SUBMISSION on

CULLEN VALLEY MINE DA 200-5-2003 MODIFICATION

Conceptual Year 2 Mine Plan

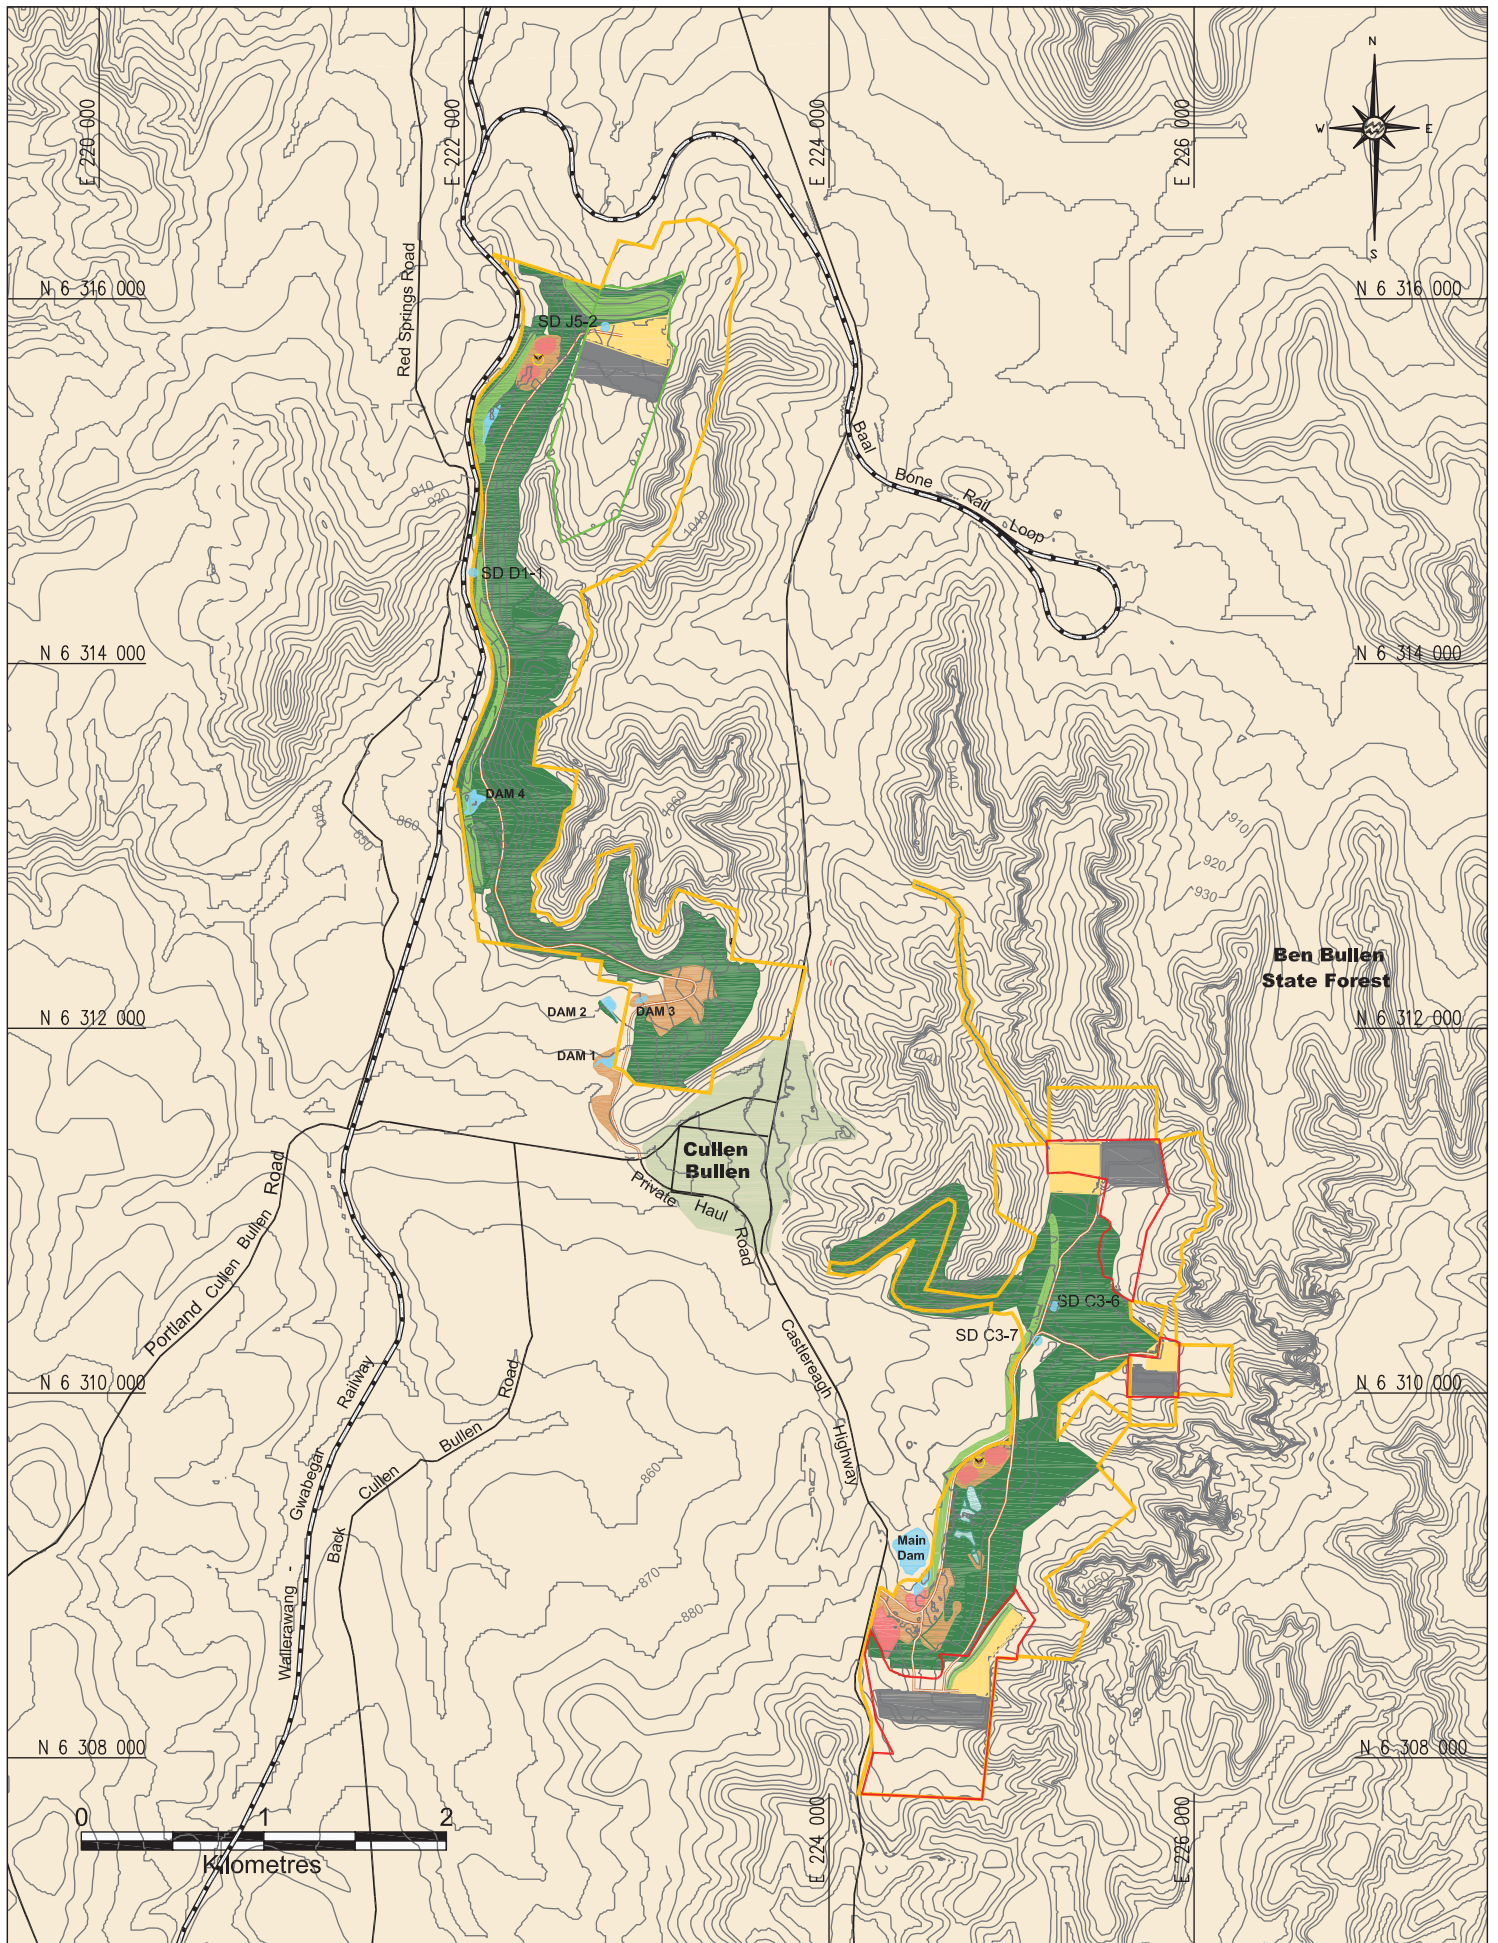
The previously mined areas have only been partly rehabilitated, and to a very poor standard. If the modification is approved, why would this poor performance suddenly change, and the whole area be totally rehabilitated by Year 2 as Coalpac says will happen? (see Figure 5, p.35)

It is claimed in the proposed modification that **all the disturbed areas** (of both mines) will be rehabilitated by Year 2 of the Conceptual Mine Plan (see Figure 5, p.35).

CONCEPTUAL REHABILITATION – 7 YEARS POST-MINING VIEW LOOKING WEST

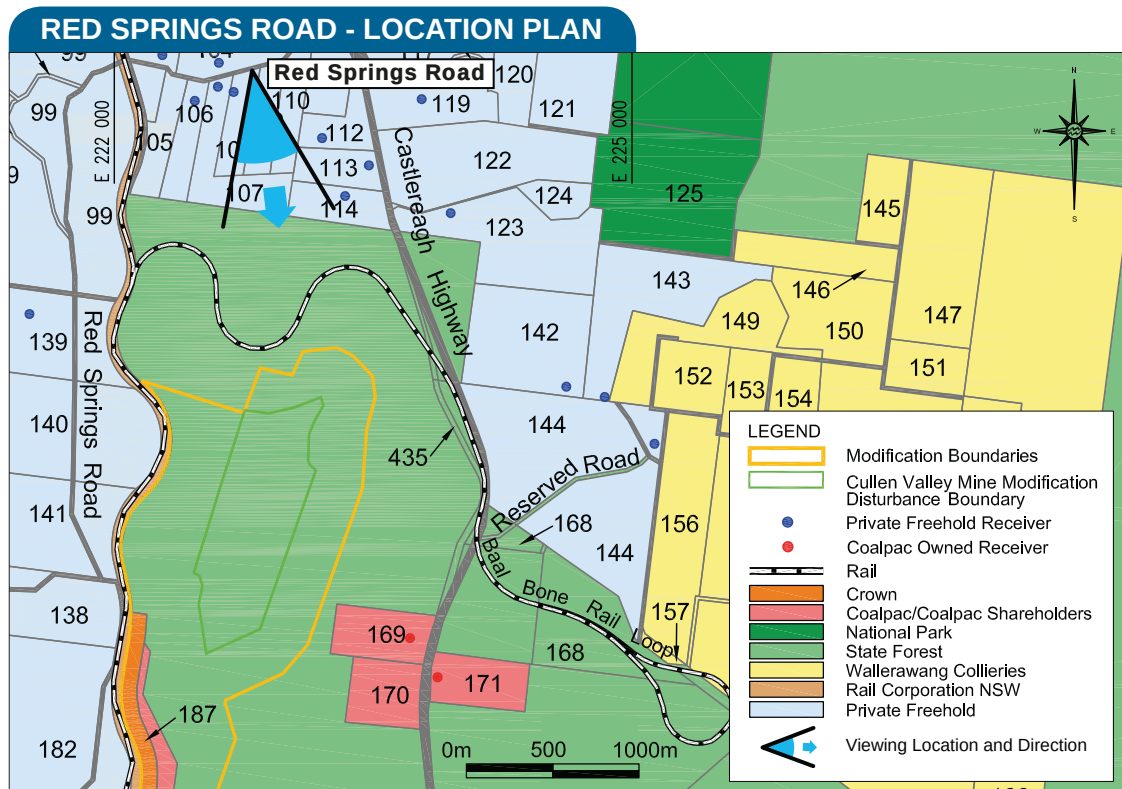
- Conceptual Rehabilitation 7 years & 20 years Post-mining shown on Figure 19, p.115 is bit of Photoshop editing to adjust the colour of the (mostly) acacias used in rehabilitation. Wattles miraculously become eucalypts!
